**PLANNING APPLICATION 20/02060/F**  
**THE STABLES, MAIN ST, GREAT BOURTON, OX17 1QU**

1. This letter sets out our objections and comments on the proposed ‘change of use of land to a mixed use for the keeping of horses (existing) and as a residential caravan site for four Gypsy families. Each with two caravans (including no more than four static caravans/mobile homes) together with the laying of hard core’.

# SITE LAYOUT PLAN

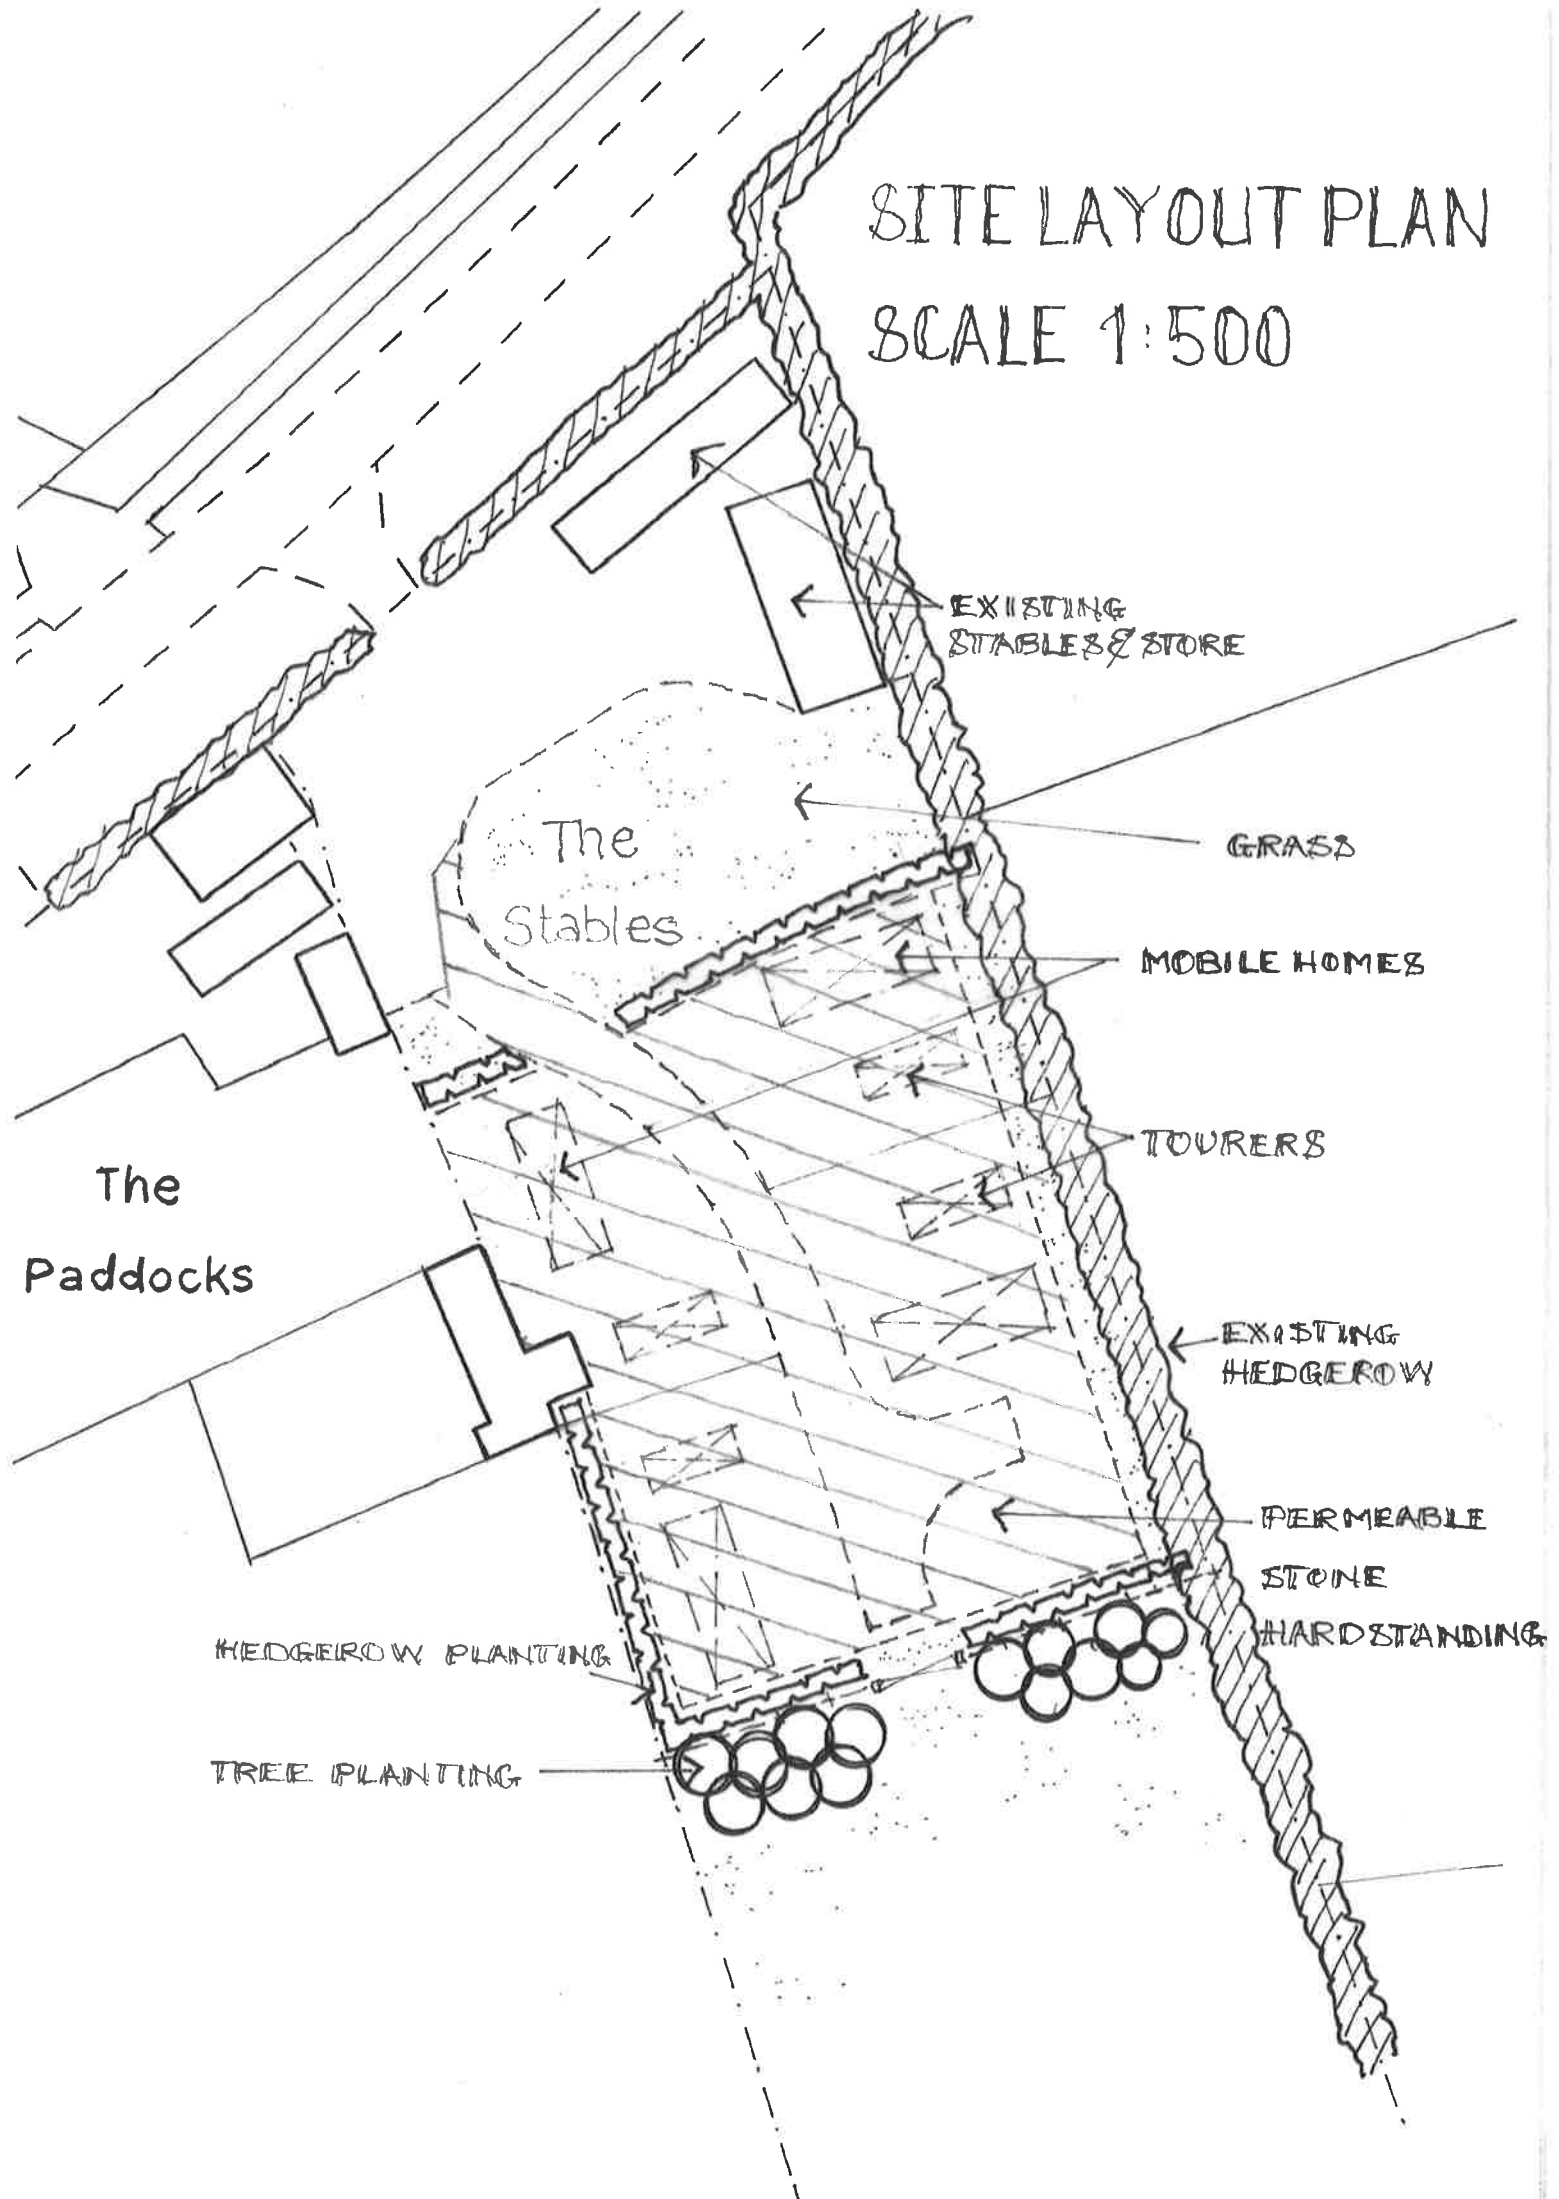
5. **Waste Disposal.** In Section 7 of the planning application, Waste Storage and Collection, the plans do not incorporate areas to store and aid the collection of waste and arrangements have not been made for the separate storage and collection of recyclable waste. There is concern that this does not seem to correspond with Cherwell District Councils policy on recycling where possible.

8. **Obstruction of a Public Footpath.** The site would obstruct the Public Right of Way on the footpath between Little Bourton and Cropredy, which currently gives walkers access to and from the road. Footpath 8 diagonally crosses the site, although this is not shown on the map used for this application. The positioning of caravans, vehicles and associated paraphernalia as part of the transition to a residential site would make this part of the footpath difficult to negotiate and walk through.
